Project Name: NORTH ALBUQUERQUE ACRES UNIT A

LYLE J HOFFERTH agent(s) for GRACE CHURCH request(s) the above action(s) for all or a portion of Lot(s) CDS-1A, Block(s) 20, **NORTH ALBUQUERQUE ACRES Unit(s) A**, zoned C-1, located on SAN ANTONIO NE BETWEEN LOUISIANA NE SAN PEDRO NE containing approximately 8.1 acre(s). (D-18) [*Deferred from 8/6/08 & 8/13/08*] **THE SITE DEVELOPMENT PLAN FOR BUILDING PERMIT WAS APPROVED WITH FINAL SIGN-OFF DELEGATED TO CITY ENGINEER FOR SIA AND FOR APPROVAL FROM SOLID WASTE. 3 COPIES OF THE APPROVED SITE PLAN MUST BE PROVIDED TO PLANNING.**

**RE:** Project # 1001904 (Site development plan for building permit)

7. **Project #1001904**  
**Application # 02DRB-00626**  
**Grace Church**

PROJECT #1001904

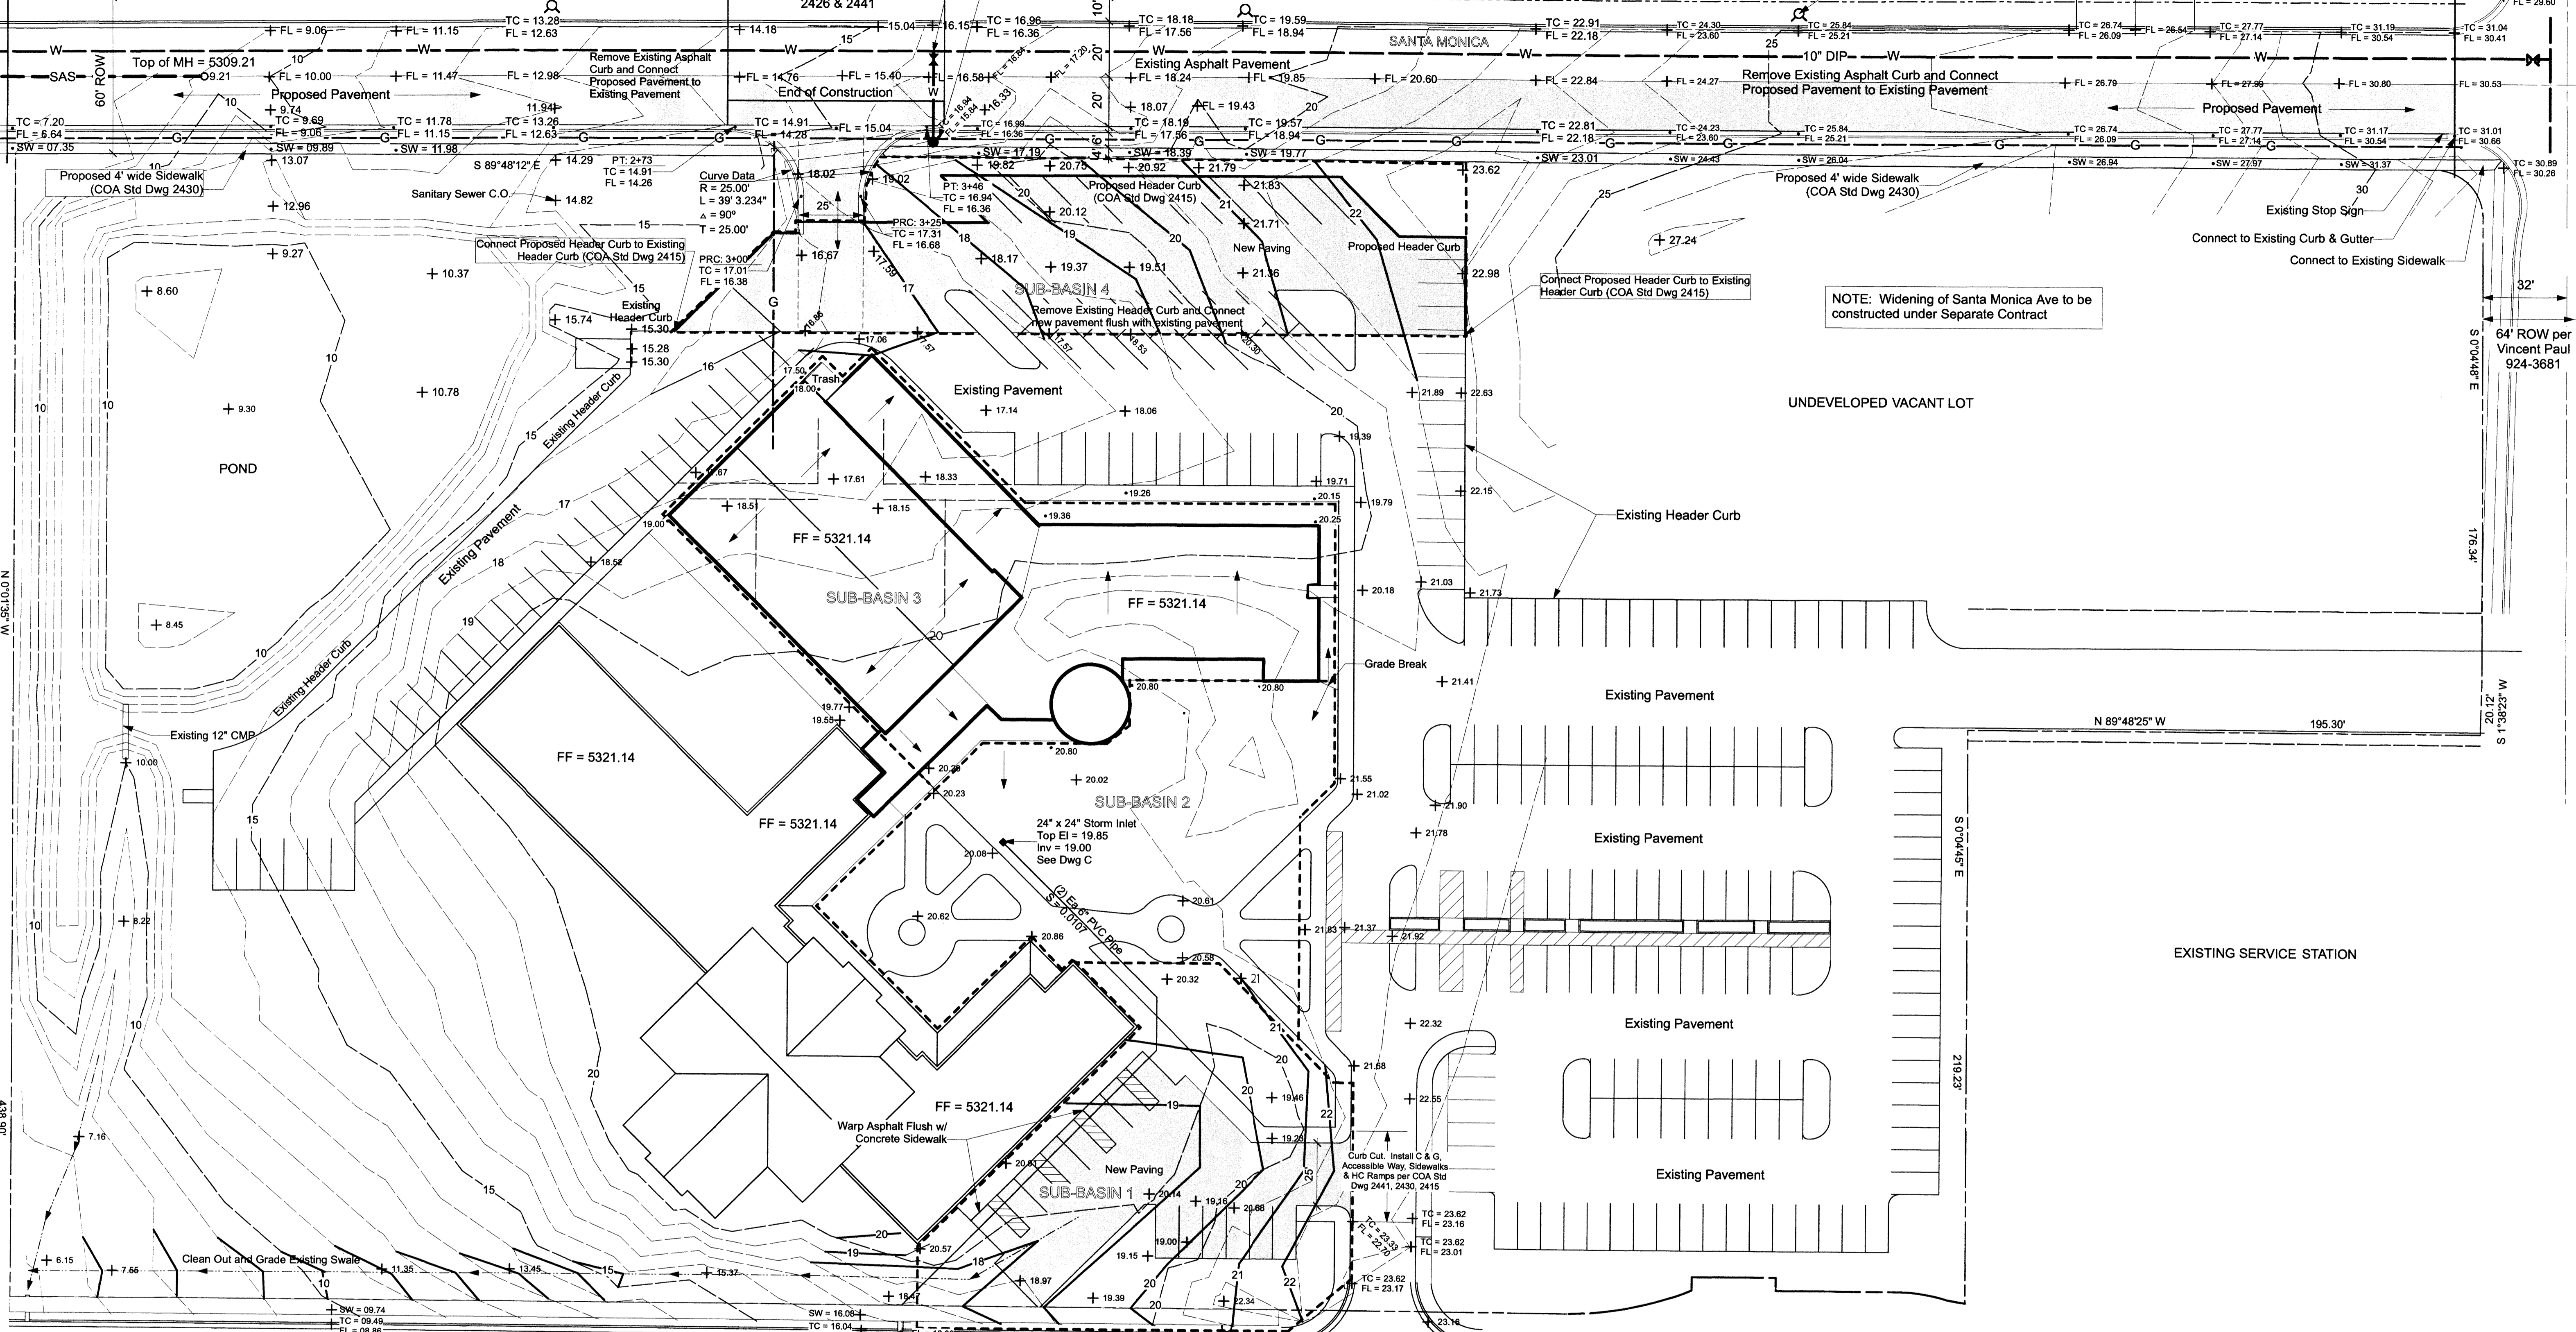
- 9 TRANSPORTATION: address Santa Monica Improvement
- 9 UTILITIES: Fire Flow Calculations
- 9 CITY ENGINEER / AMAFCA: \_\_\_\_\_
- 9 PARKS / CIP: \_\_\_\_\_
- 9 PLANNING (Last to sign): See comments
- 9 Planning must record this plat. Please submit the following items:
  - The original plat and a mylar copy for the County Clerk.
  - Tax certificate from the County Treasurer.
  - Recording fee (checks payable to the County Clerk). RECORDED DATE: \_\_\_\_\_
  - Tax printout from the County Assessor.
- 9 Include 3 copies of the approved site plan along with the originals.
- 9 County Treasurer's signature must be obtained prior to the recording of the plat with the County Clerk.
- 9 Property Management's signature must be obtained prior to Planning Department's signature.

No.	Comment
<input type="checkbox"/>	The improvements for Santa Monica street needs to be addressed.

GRACE CHURCH ADDITION		
LANDSCAPING PLAN		
REV. #	DATE	PROJECT # 02013
	Apr 02	DWN BY: <i>Re</i>
		CHK BY:
		DATE: APRIL 23, 2002
		<b>C2</b>
		2 OF 4

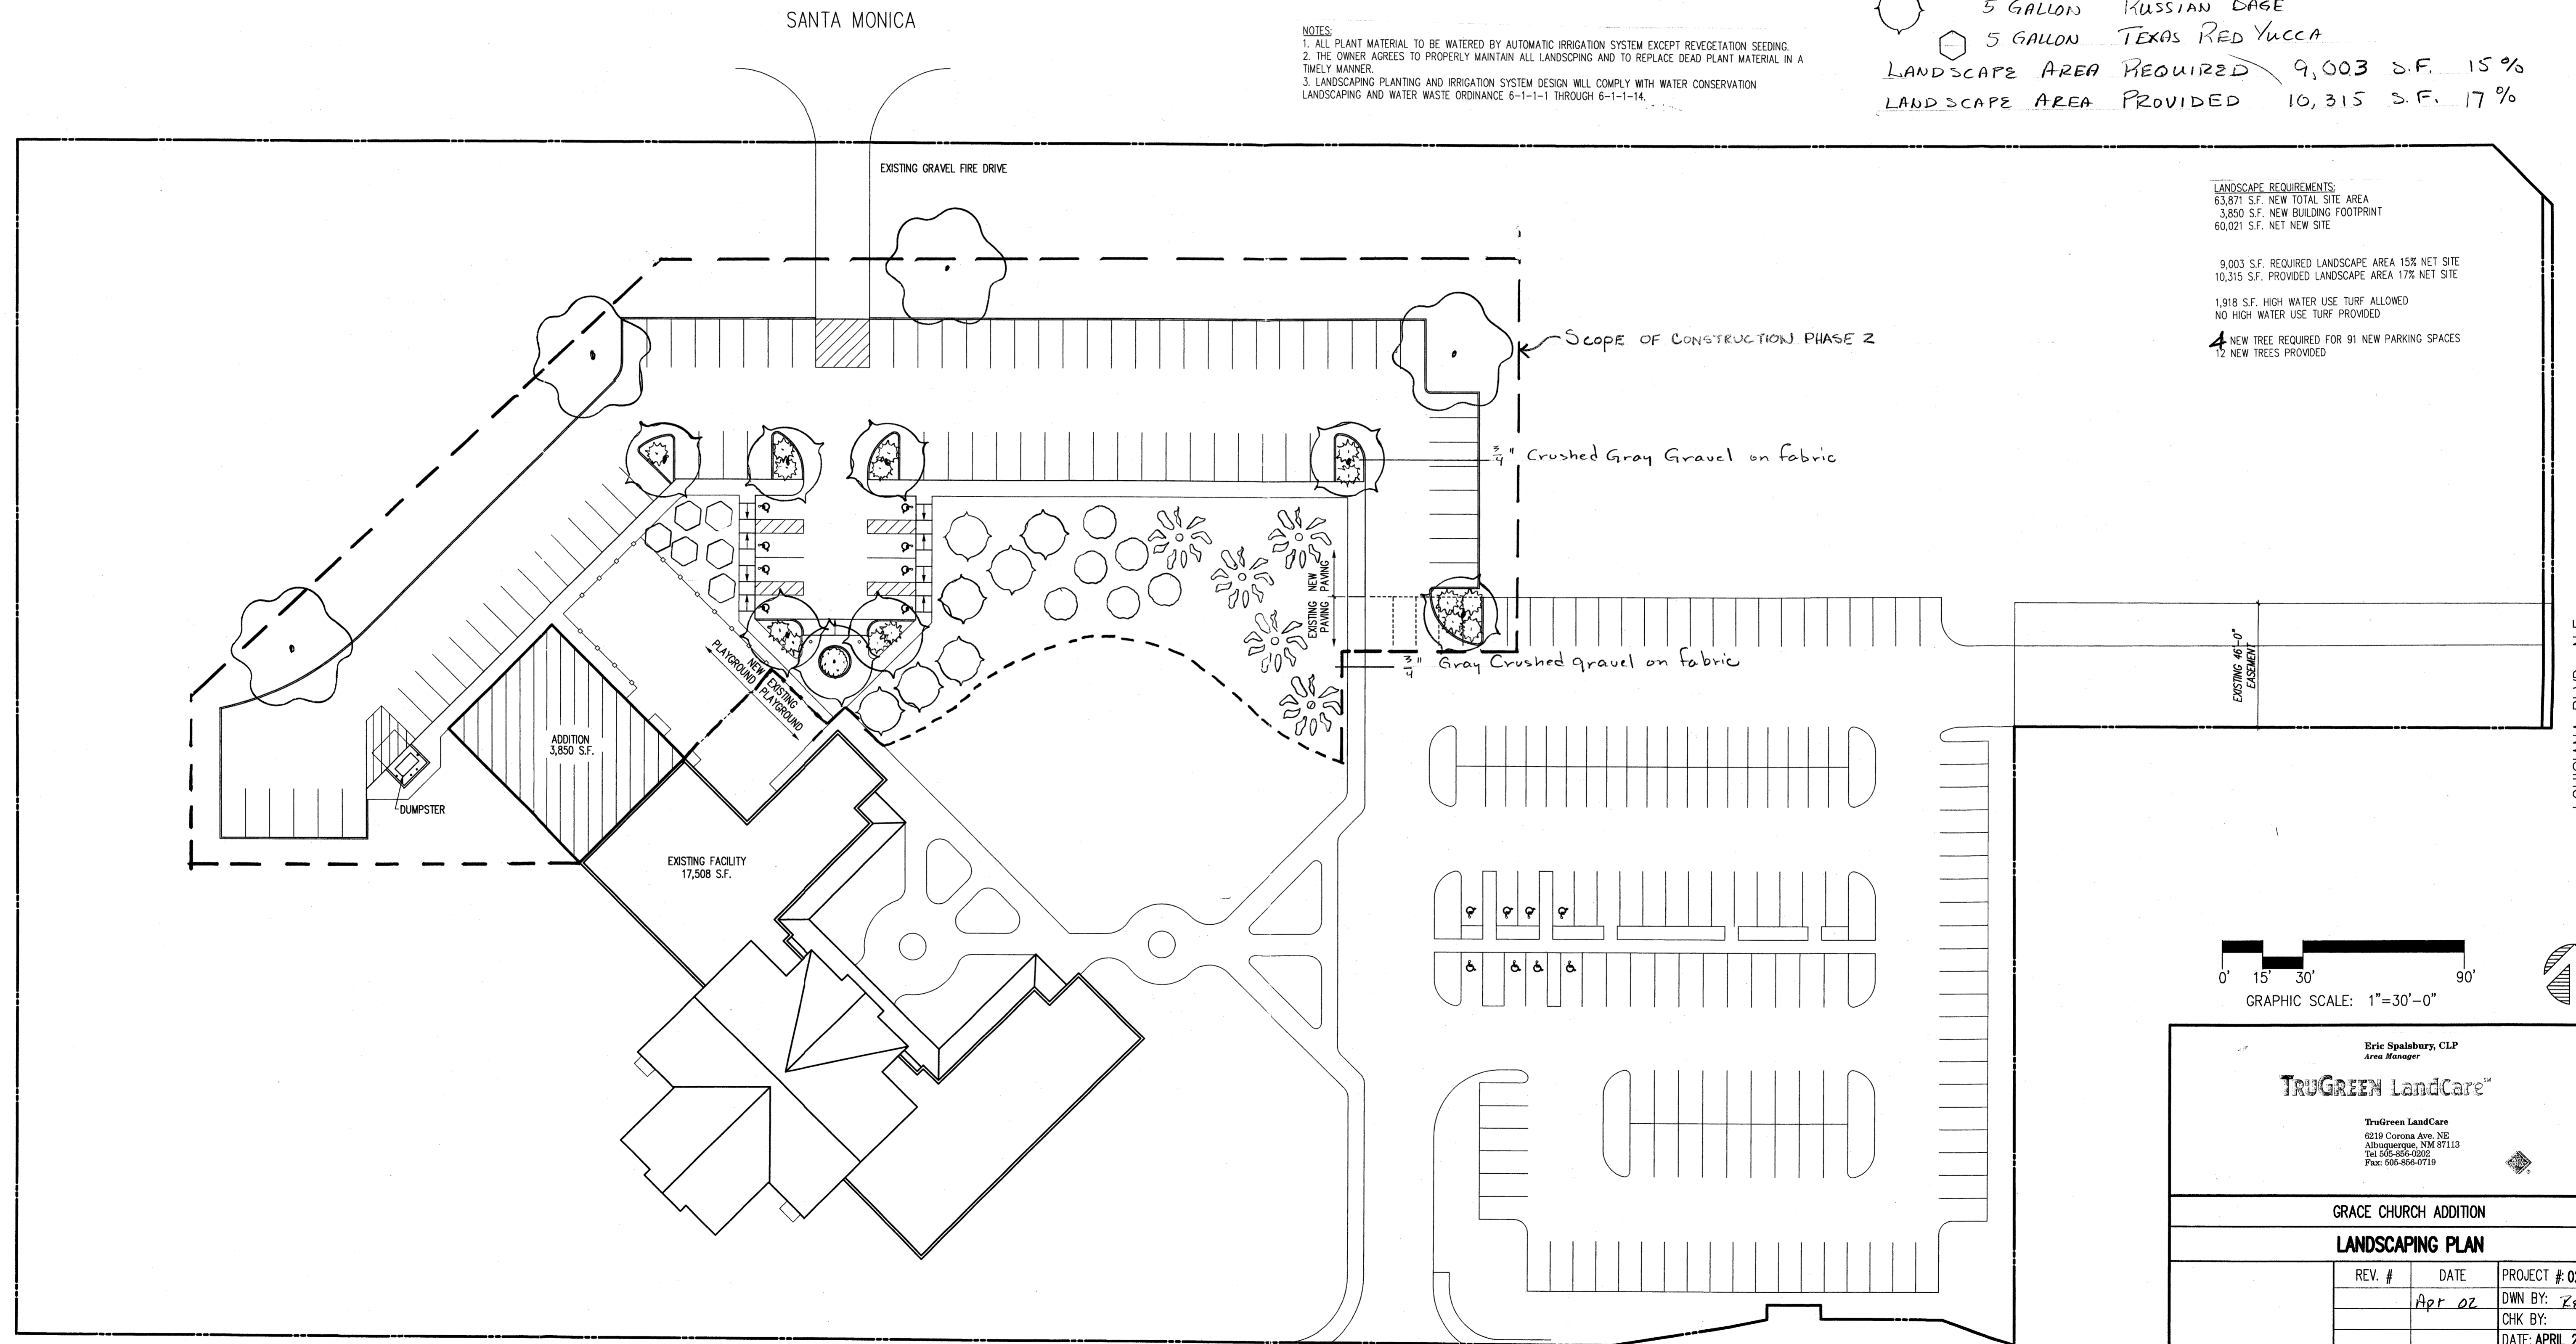
1. Please call out the colors on the elevations.
2. Specify the type of material used in the dumpster enclosure and color/s. Also, an opaque gate needs to be added to the detail.
3. The landscape plan indicates that "1 new tree required for 91 parking spaces". Please clarify/correct.
4. No objection to delaying the ten foot buffer landscaping to the next construction phase.

**DRAINAGE AND GRADING PLAN FOR PHASE 11**  
**GRACE CHURCH**

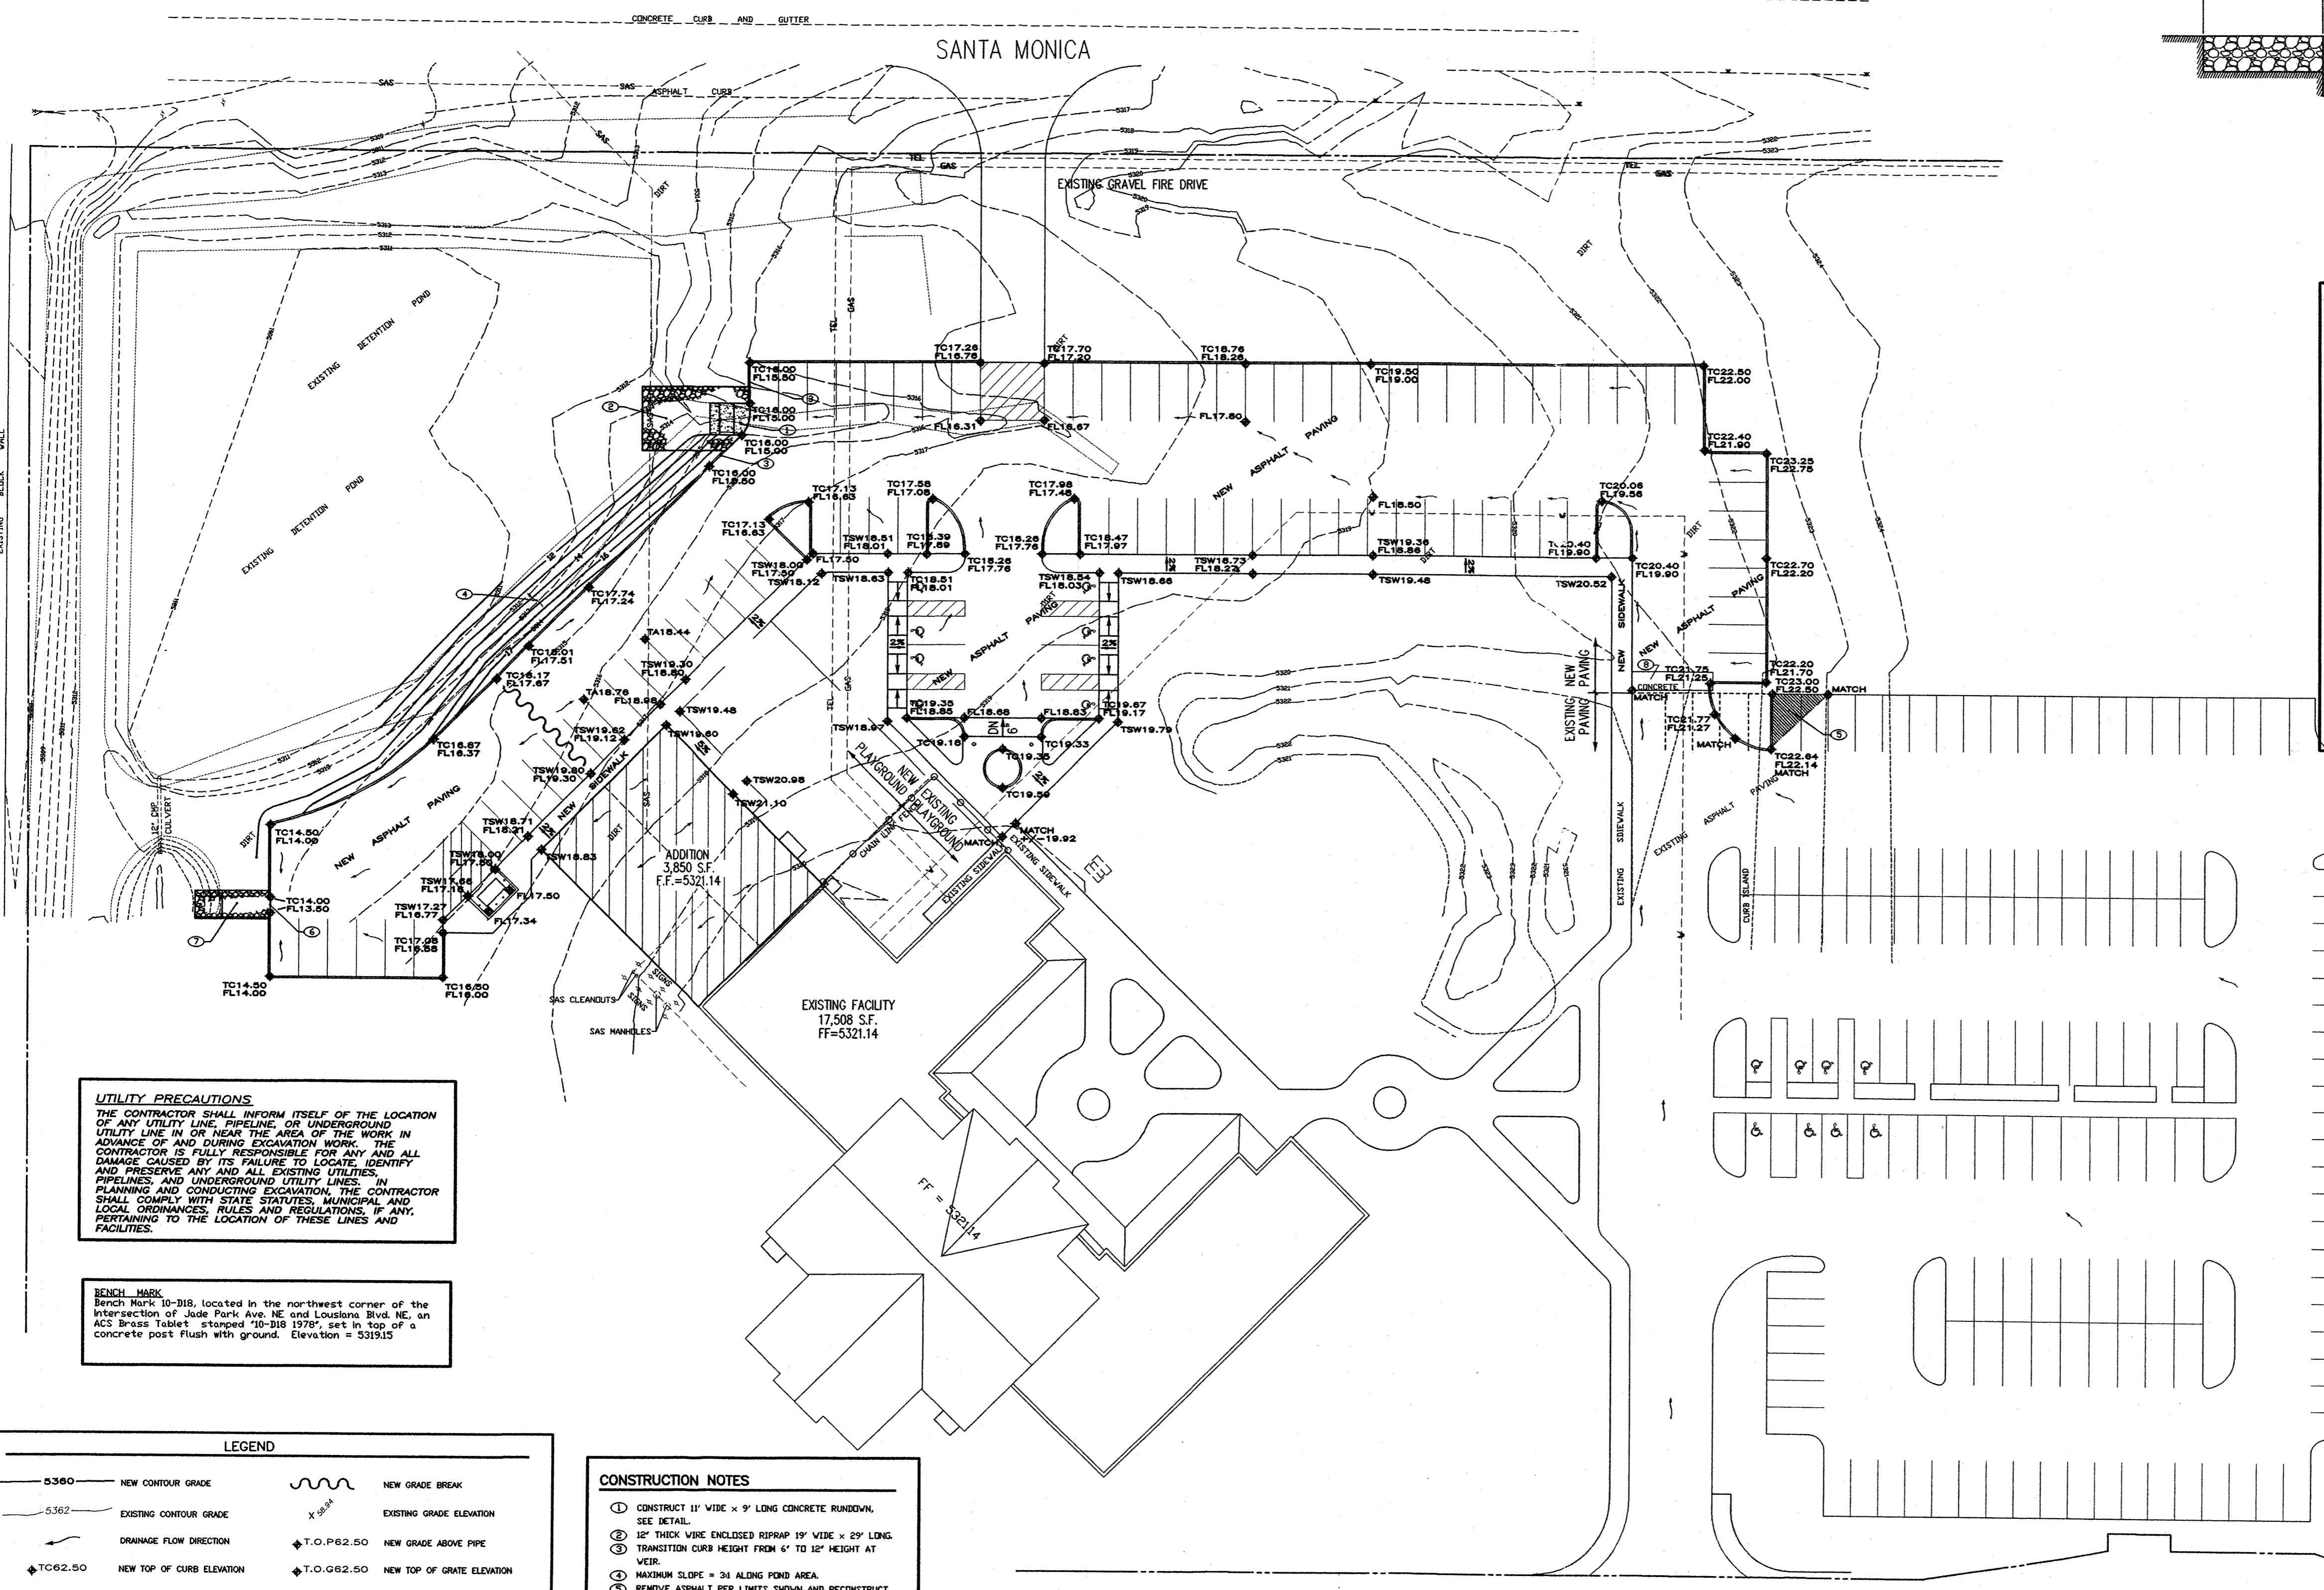
An approved conceptual grading and drainage plan dated 4-22-02 is on file for site plan sign-off by the City Engineer / AMAFCA.
